**Our Ref: A/164/11/
Your Ref:**

Please ask for:
Mrs J Grieves
Technical Support Unit Assistant
25th November 2011

**Replace 2 windows, block up 2 windows, replace fire escape & new kitchen-extract
The Lamb The Square Angmering**

BLOCK 1:500

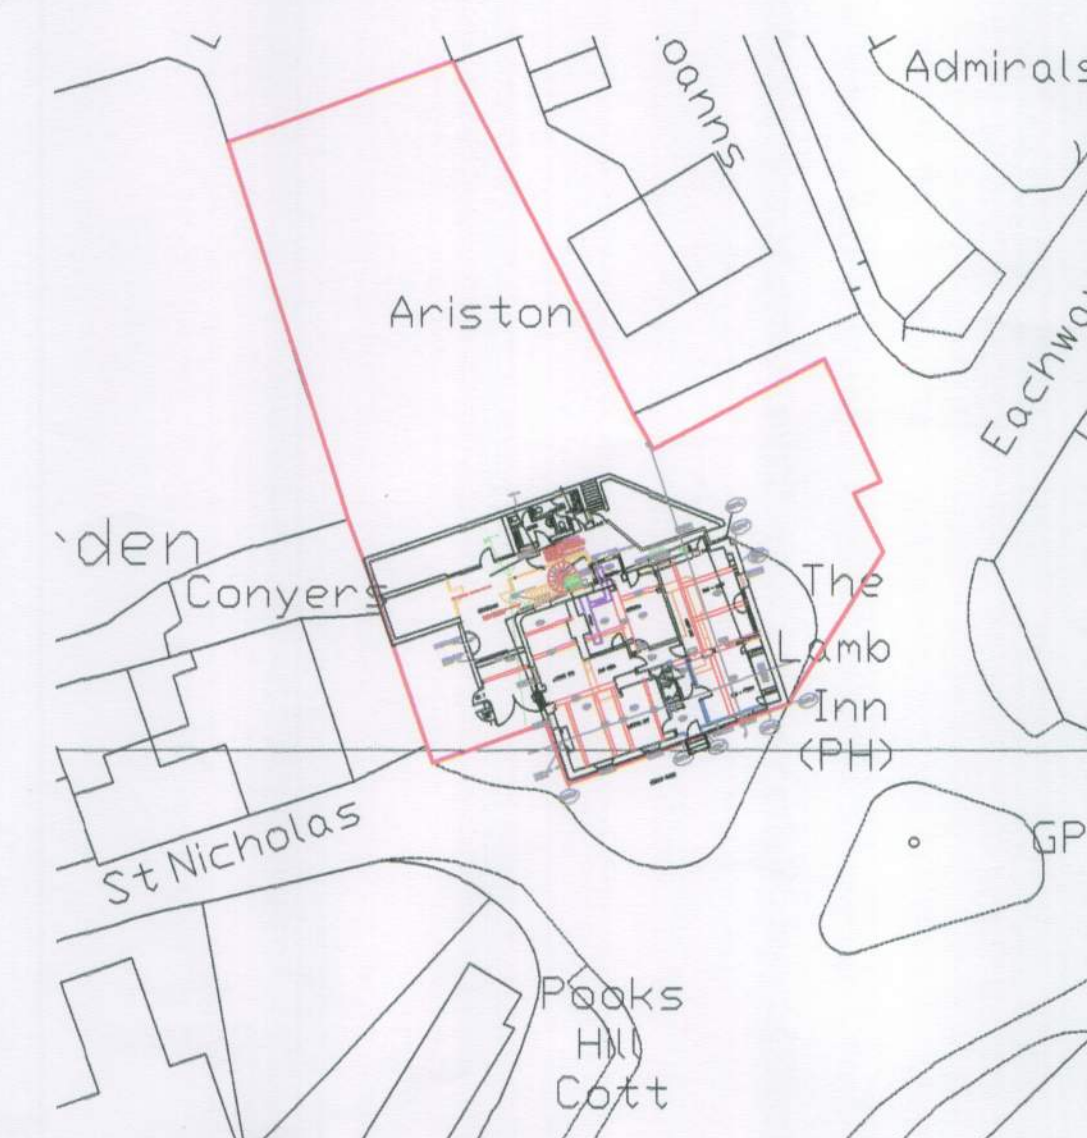
Please provide 3 copies of a block plan clearly showing the position of the proposed works

CLIENT	Mr Newbon
R3	Replace Windows removed
R2	Revisions - see notes
R1	Added windows & extract details
Issue	Details
SCALE	AS SHOWN on A1
DATE	22/11/11
DRAWING NUMBER	11045/4-02 R3

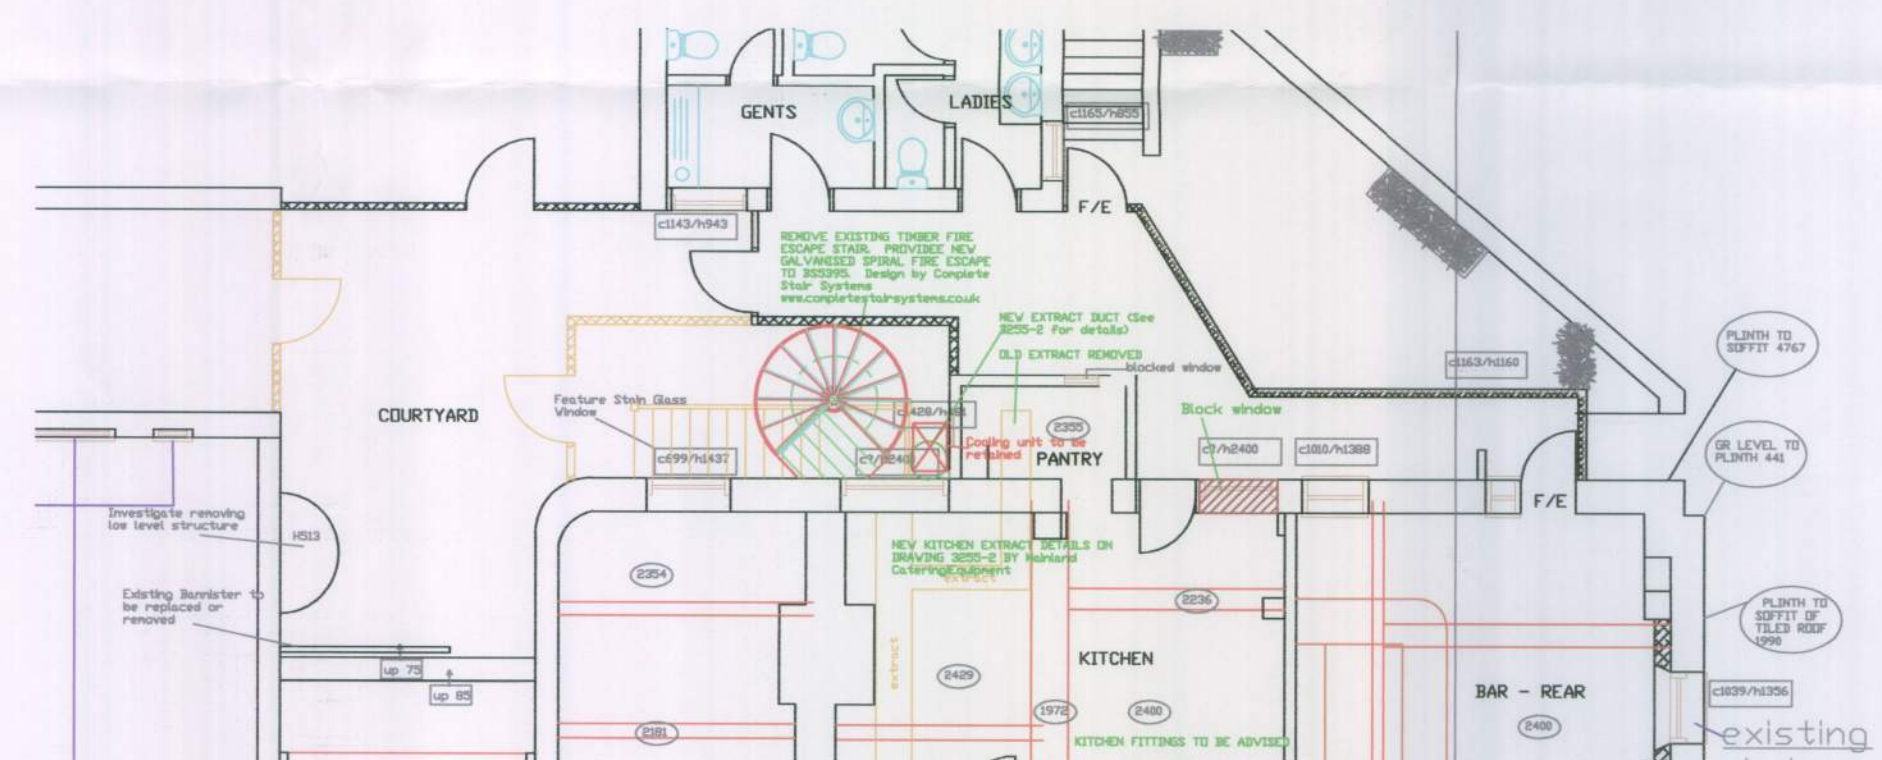
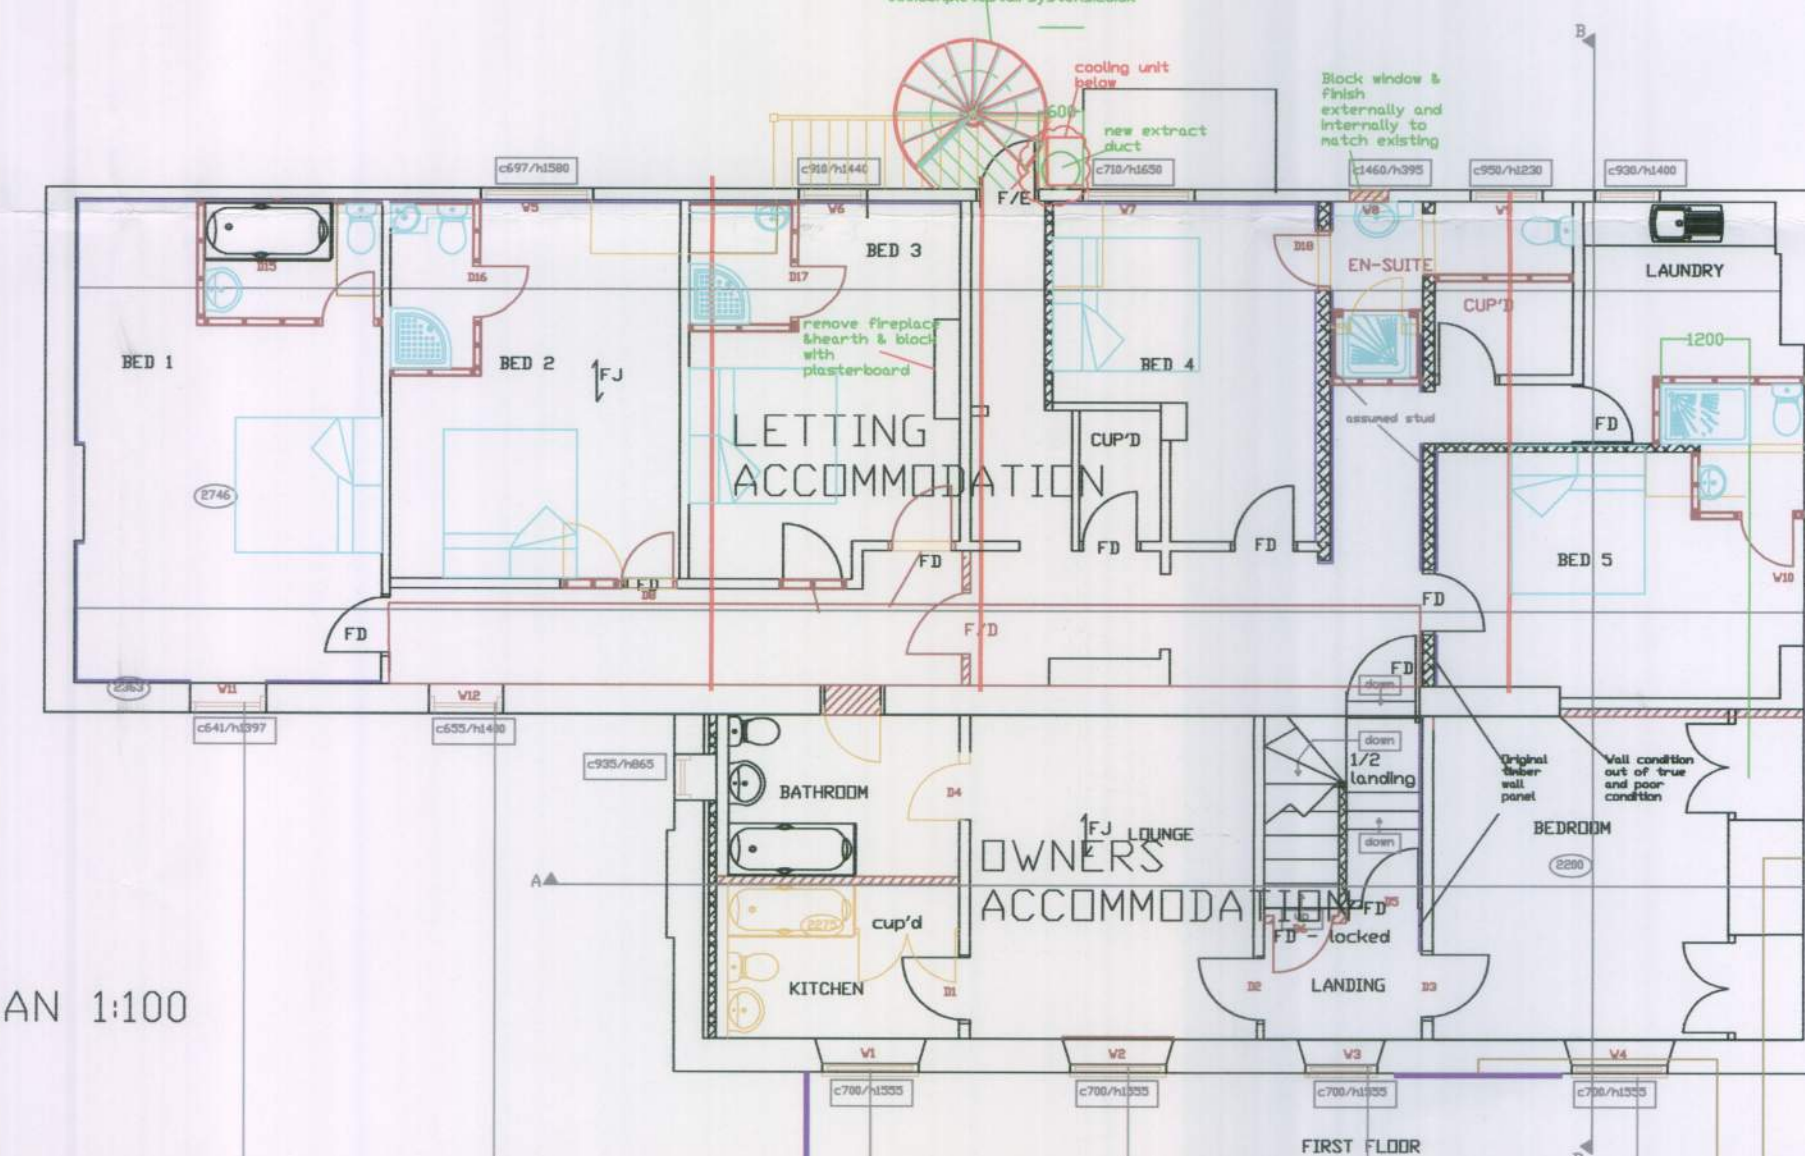
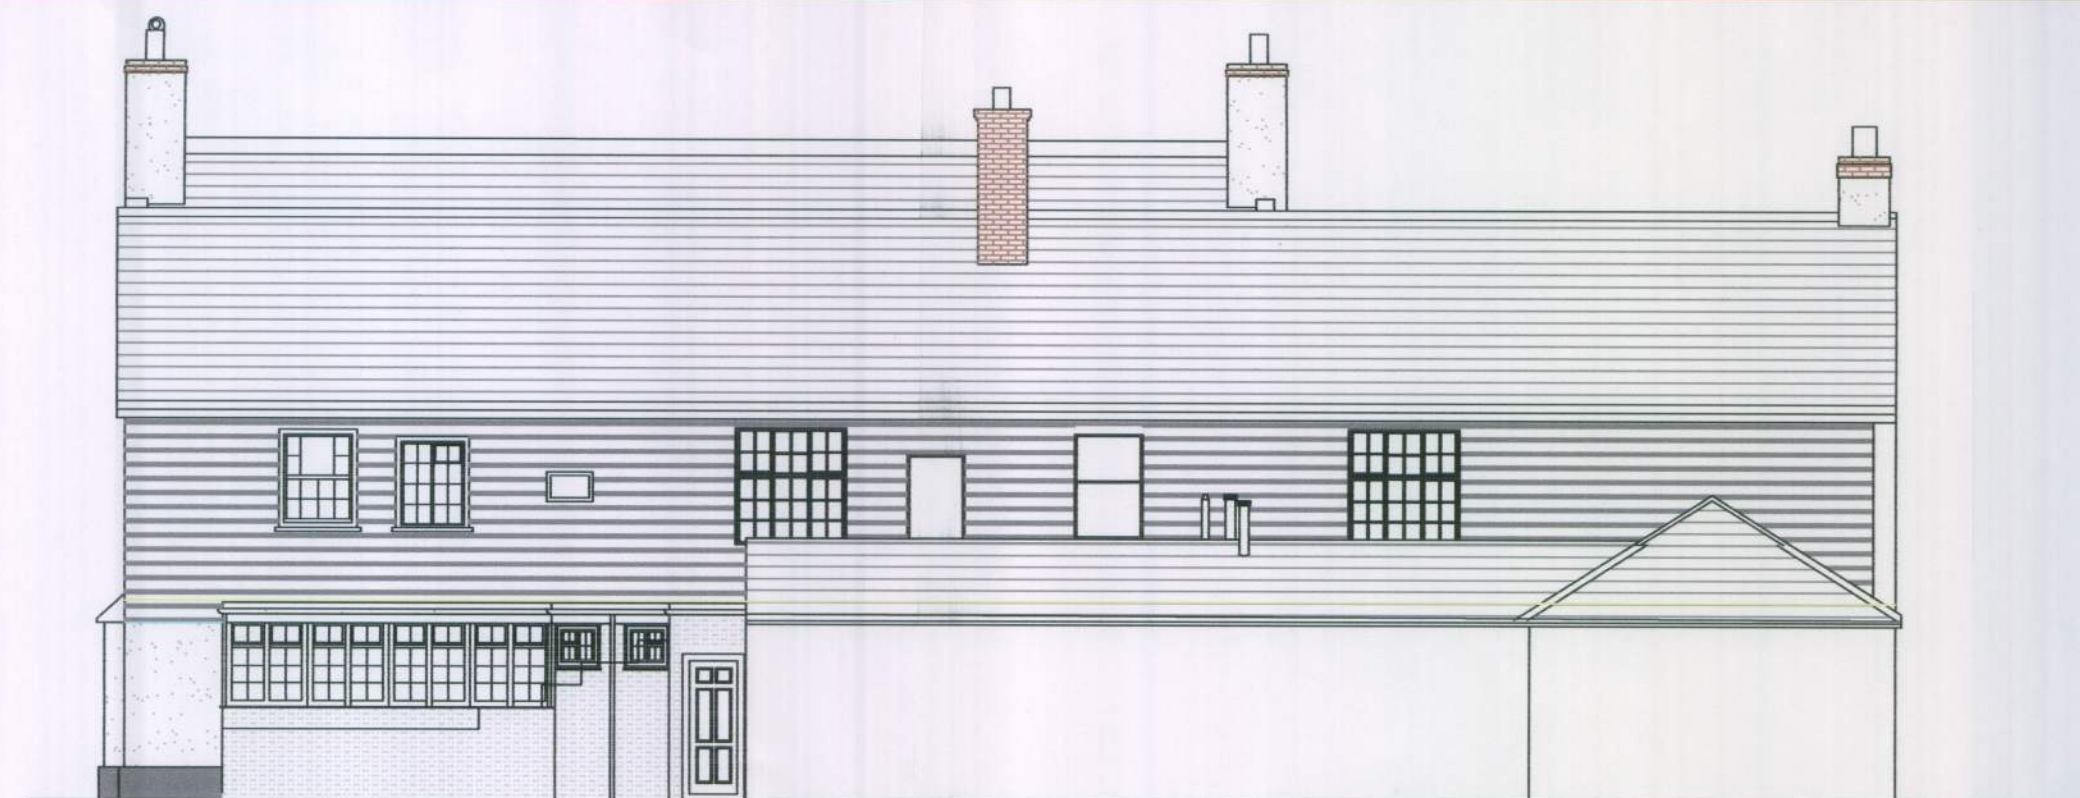
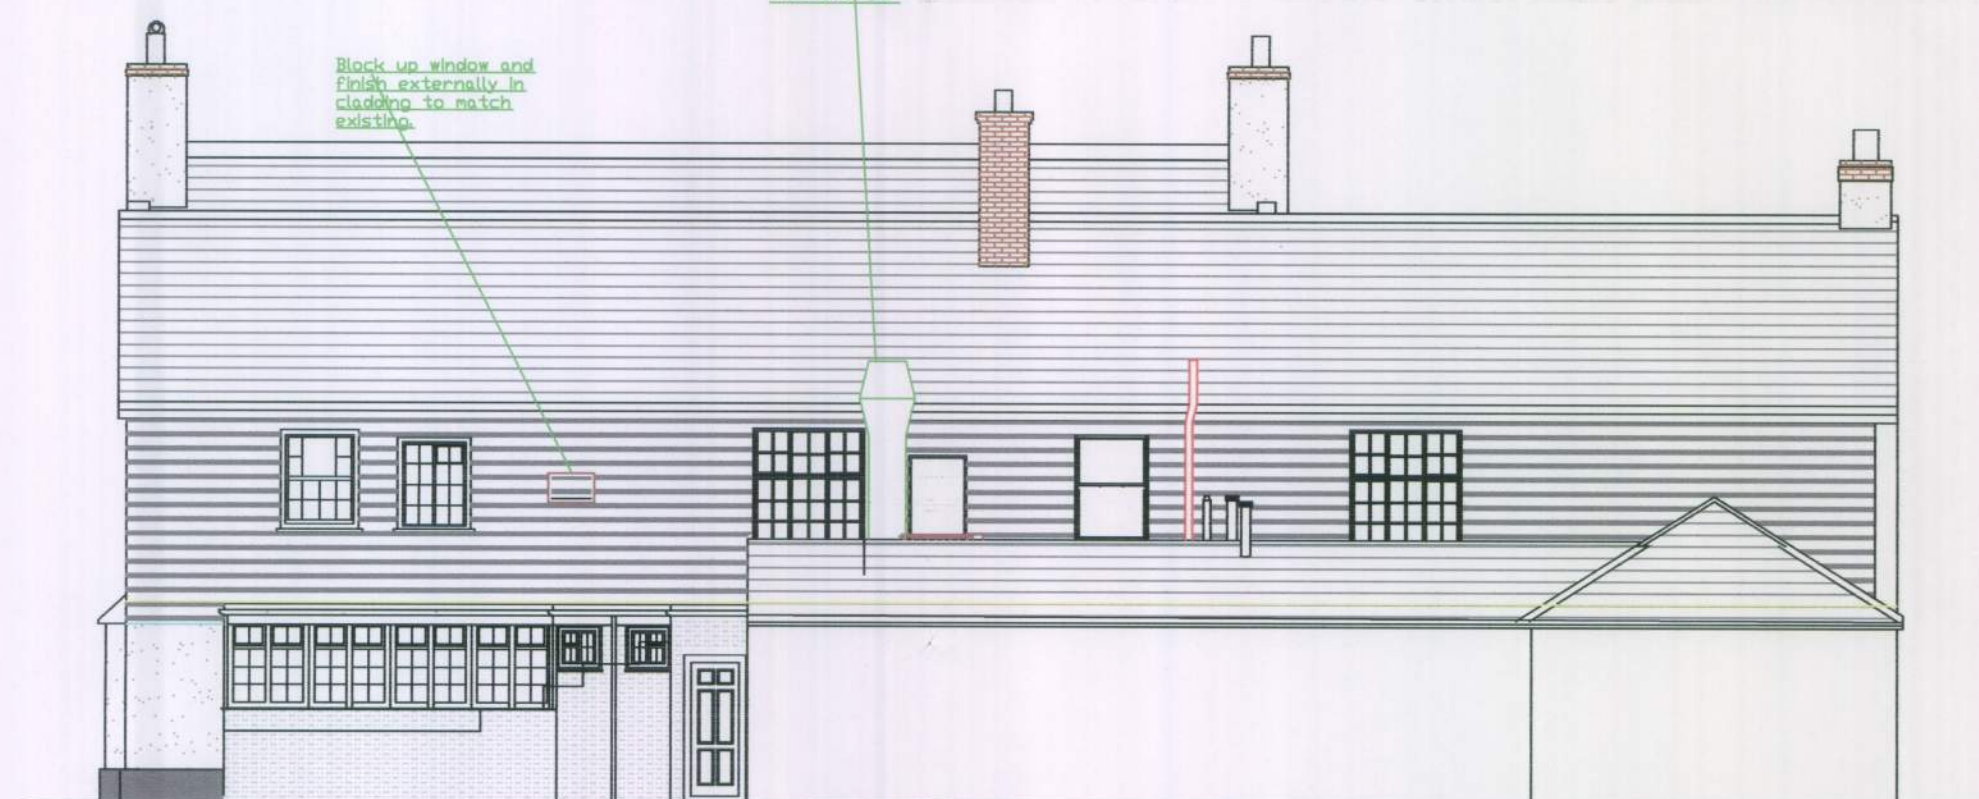
Please submit clear details of the extract system
